**CITY OF PARRAMATTA COUNCIL SUBMISSION – PROPOSED SYDNEY OLYMPIC PARK
HIGH SCHOOL - 7 BURROWAY ROAD, WENTWORTH POINT**

City of Parramatta Council thanks the Department of Planning, Industry and Environment (DPIE) for the opportunity to provide comment on the Sydney Olympic Park High School proposal. Council recognises the importance of providing a high school in this location and broadly supports the use in this location. However Council does not support this State Significant Development application (SSD) in its current form as it raises a series of concerns, particularly that it only includes the school itself and does not adequately address the immediate context of the site and the impacts on existing development approvals. For this and other reasons detailed in this submission the current proposal would provide for a poor outcome for future students and residents of Wentworth Point.

SECTION B

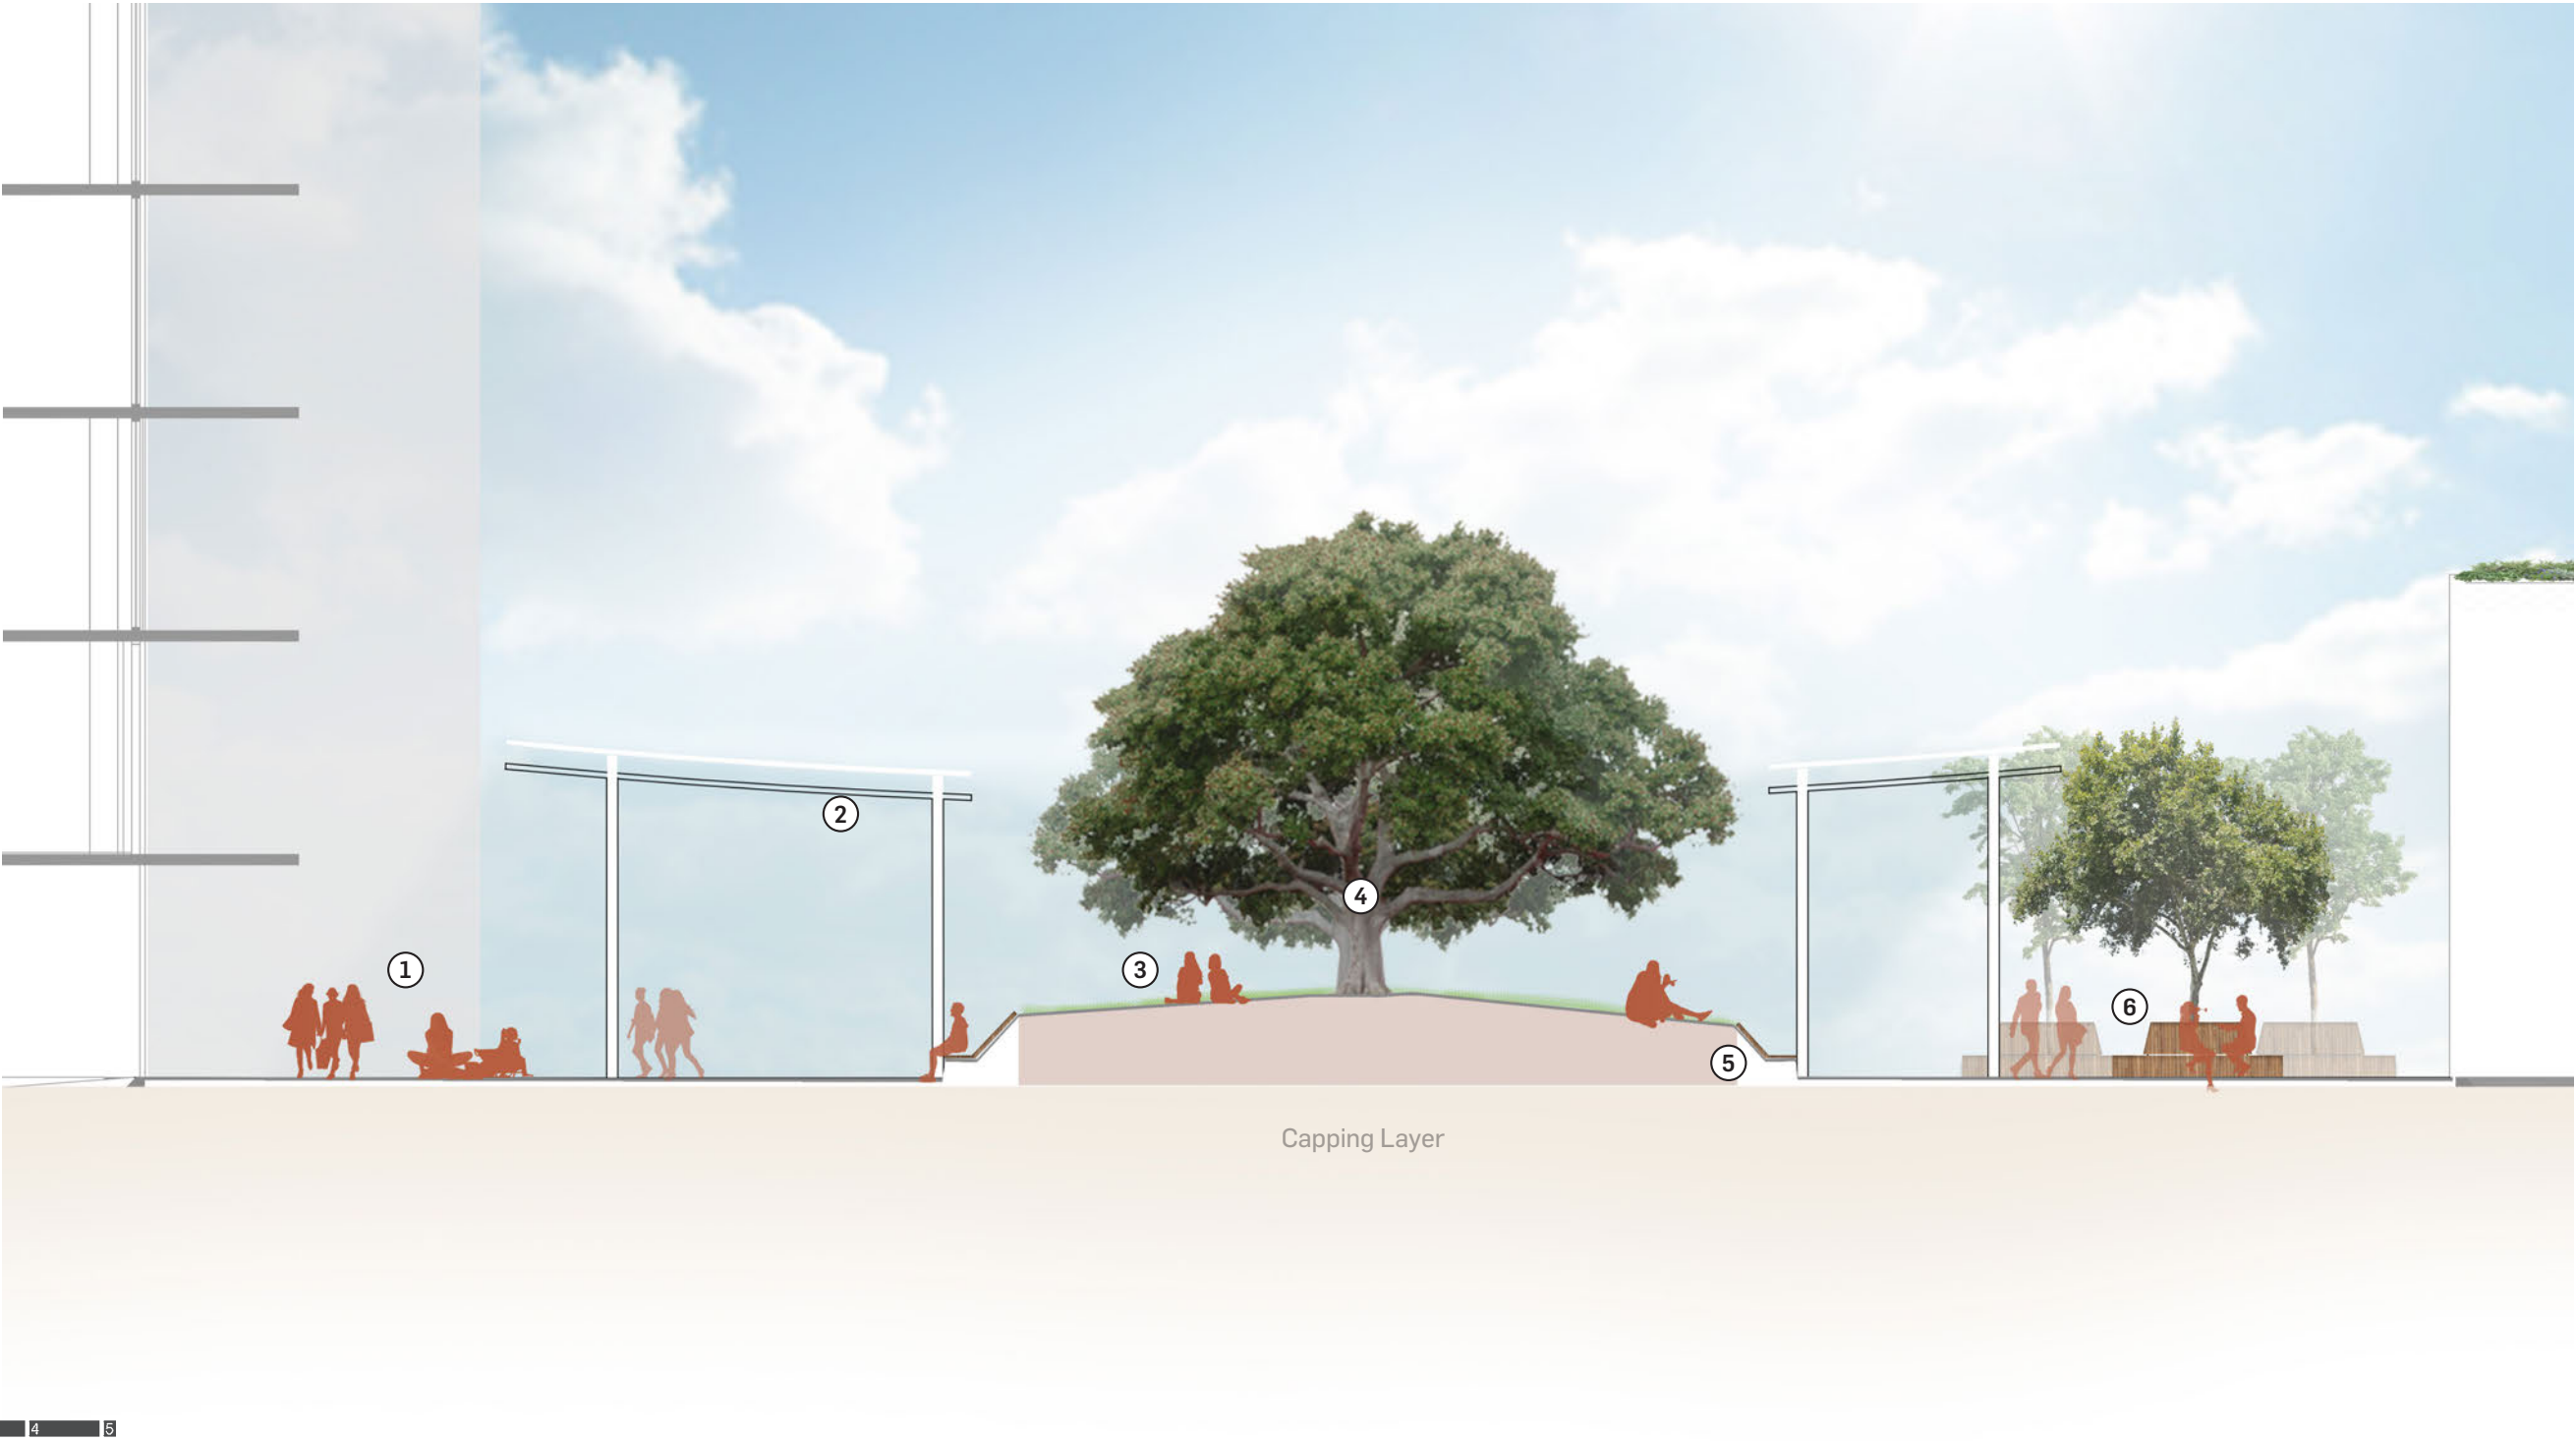
It is recommended that the proposed running track be relocated to extend around the proposed playing field instead of the indoor court to maximise existing space for the school and access by the wider community.

LANDSCAPE CONCEPT DESIGN PLAN

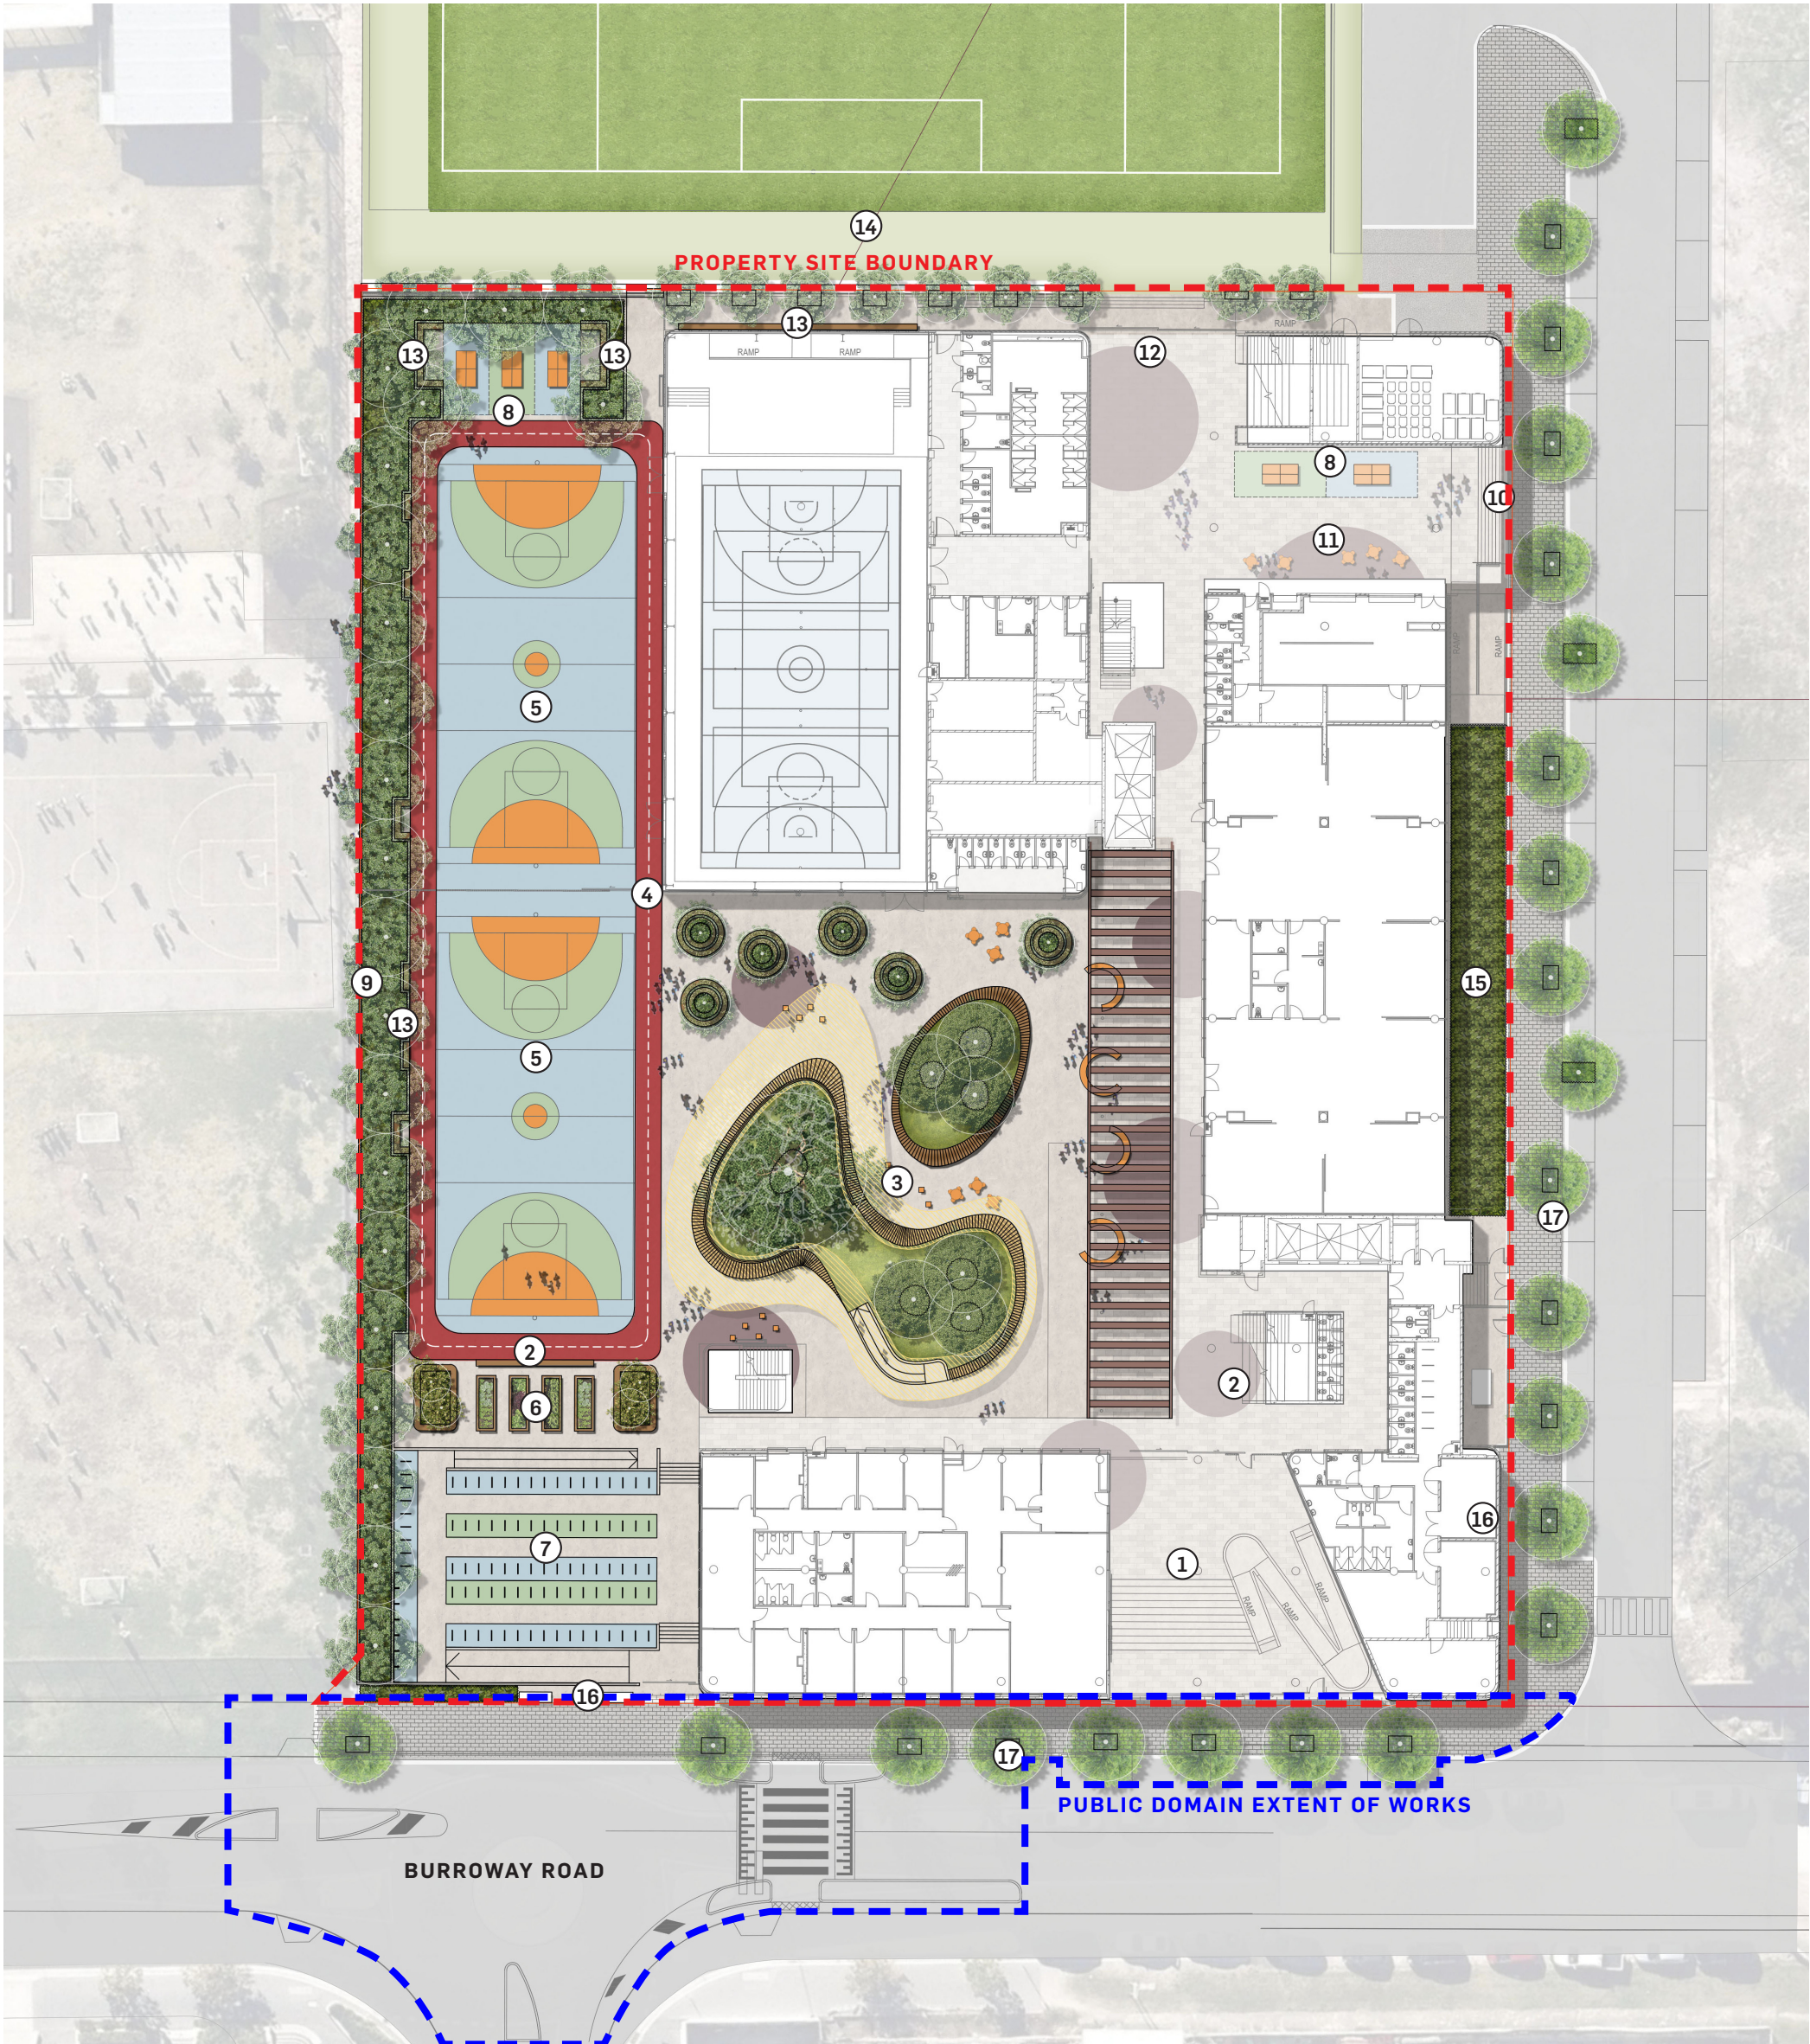
The school proposal should contribute to the development of the site's street frontage public domain. The landscape drawings provided show indicative street tree locations and vague public domain design outcomes. However, clearer public domain drawings meeting the requirements set out in the Parramatta Public Domain Guidelines (PPDG) should be provided.
